**RFI**

**RFI #:** 138  
**Date:** 6/1/2012  
**Job:** EB-02 Keller Springs Lofts  
**Phone:** 877-777-5115

**Subject:** Window Header Height

2.0
 SCHEDULE

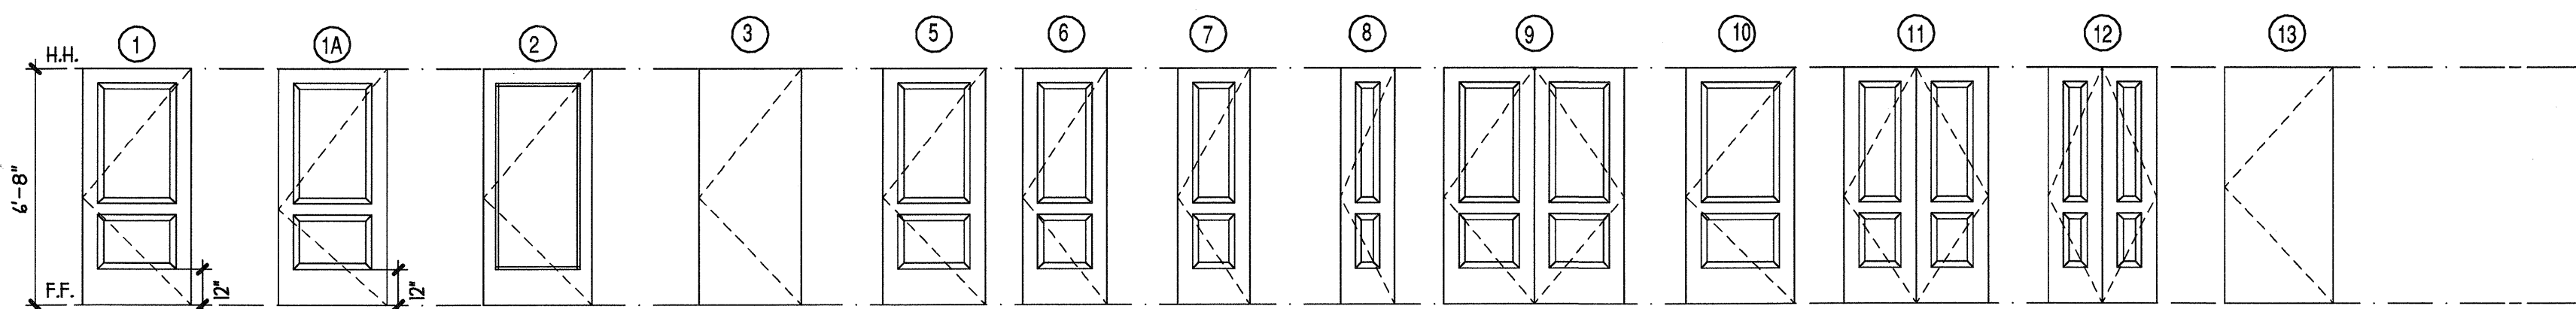
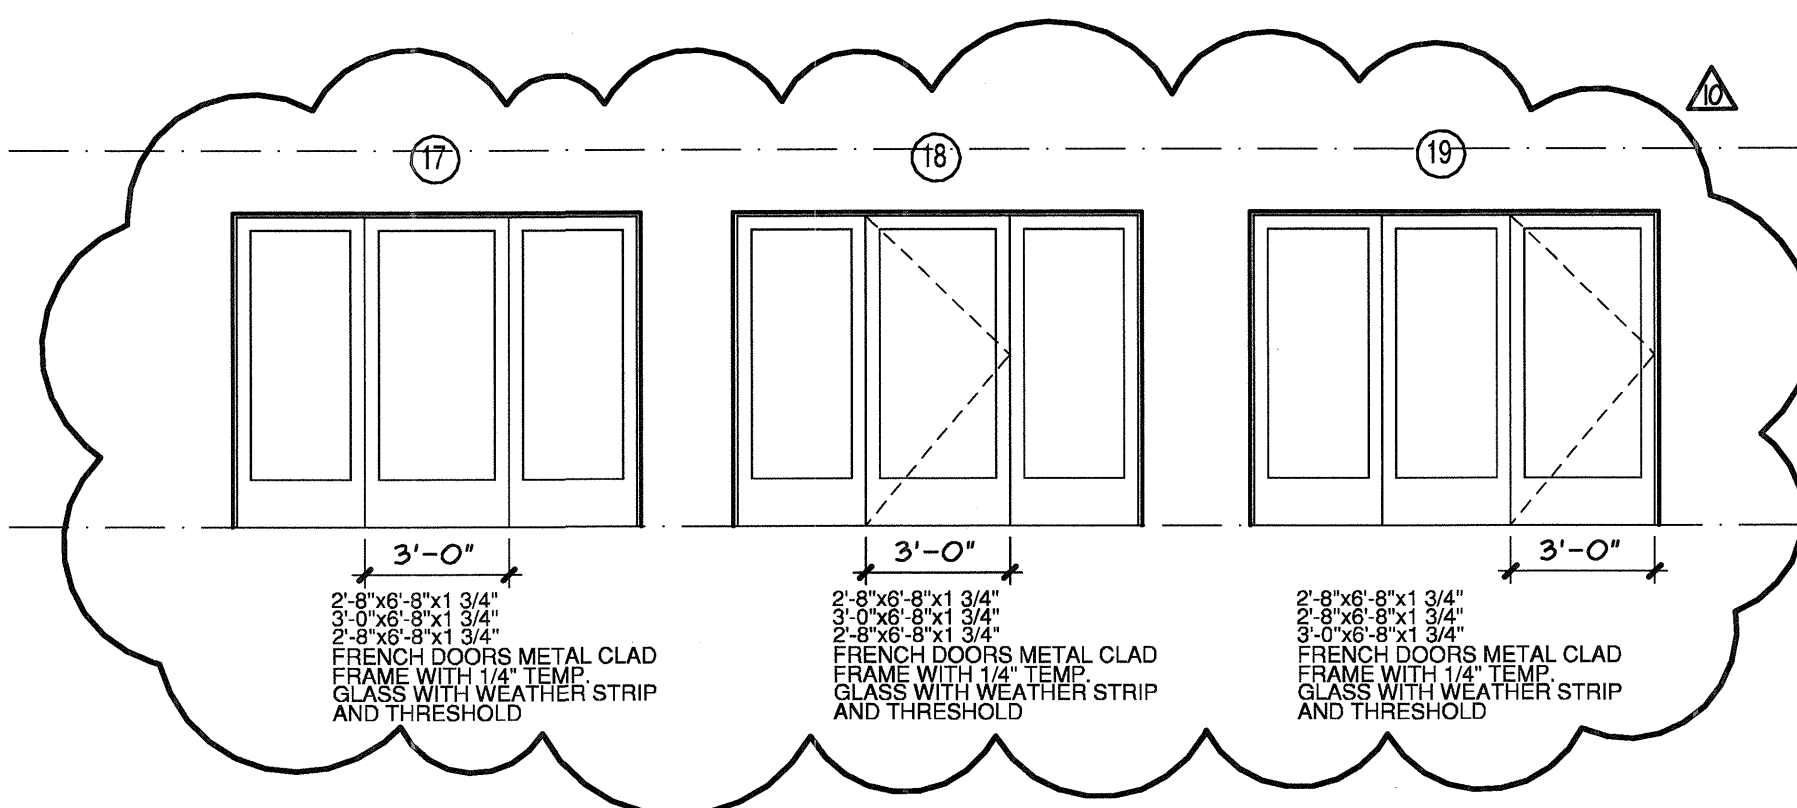
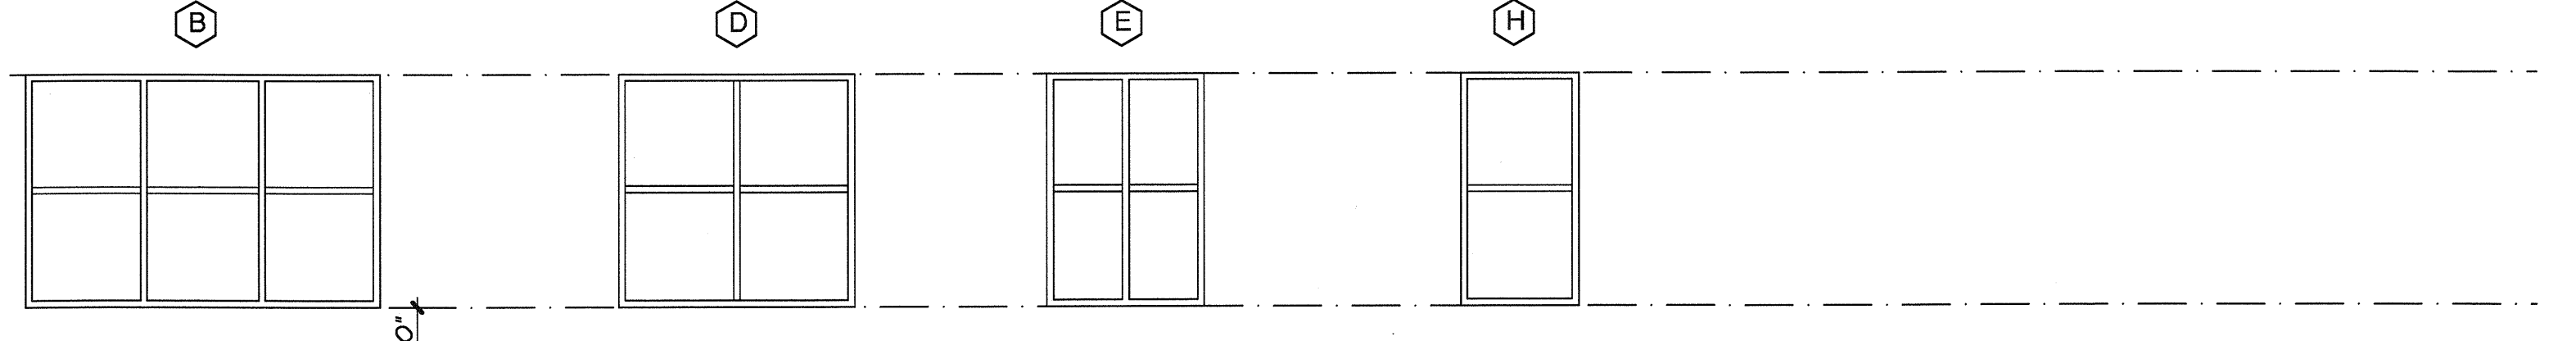
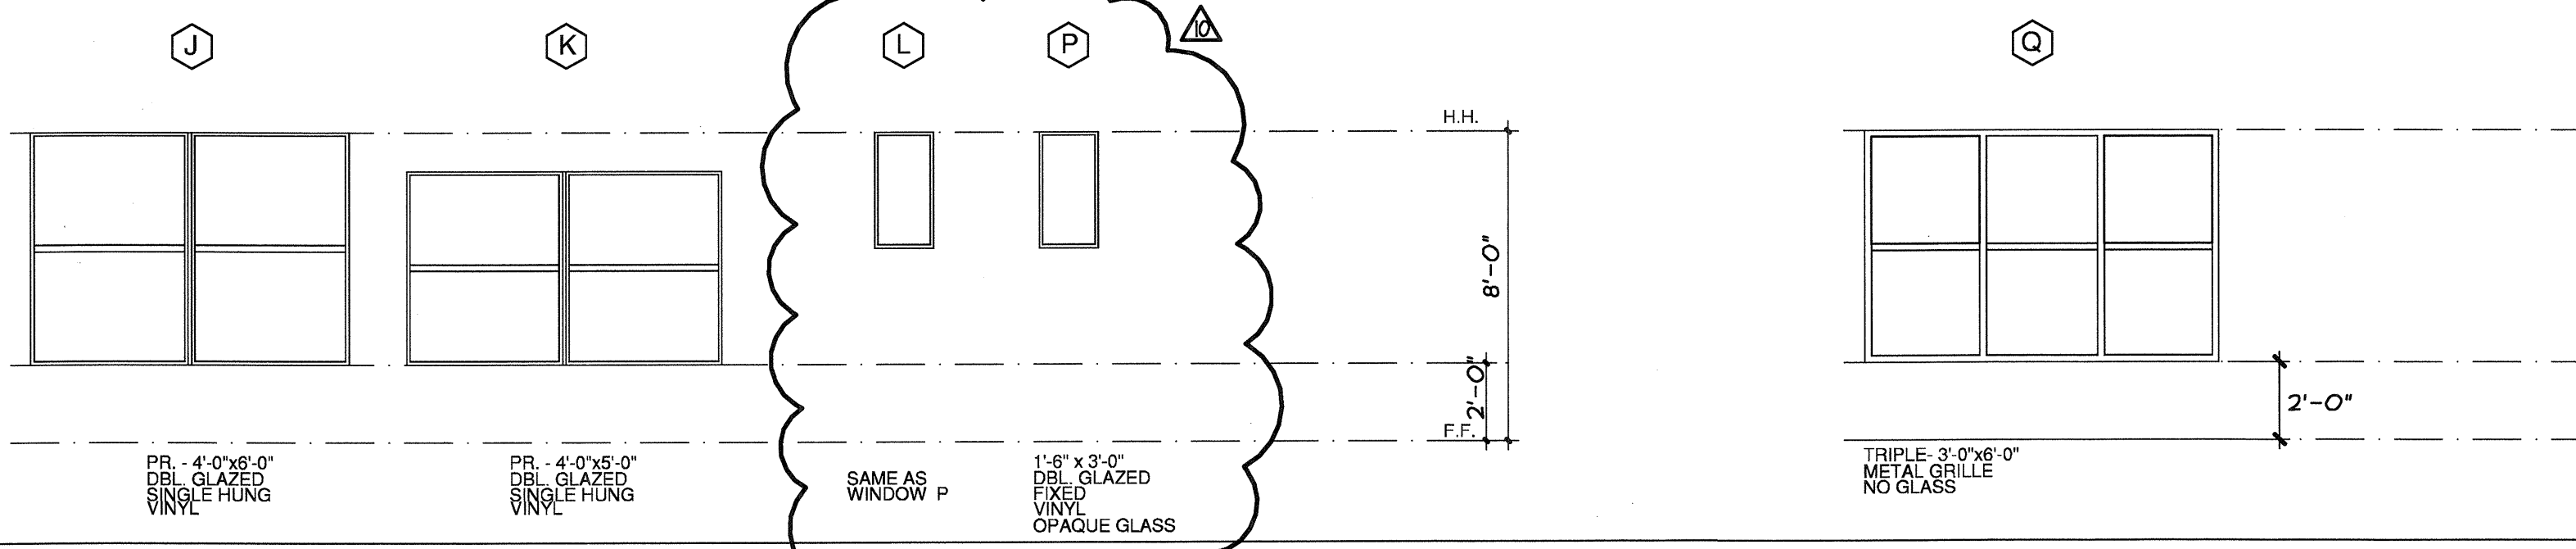
**Request:** A2.0 calls out the standard header height to be 9'-0". This height will not work in situations where there is a 2x12 header. This occurs in several unit types. Please let us know if you would like to remove the top plate or drop the standard header height down a couple of inches.  
**Date Required:** 6/11/2012

**Response:** Yes.  
I agree.  
But, taking out the bottom top plate is only need when a 2x12 header is used.
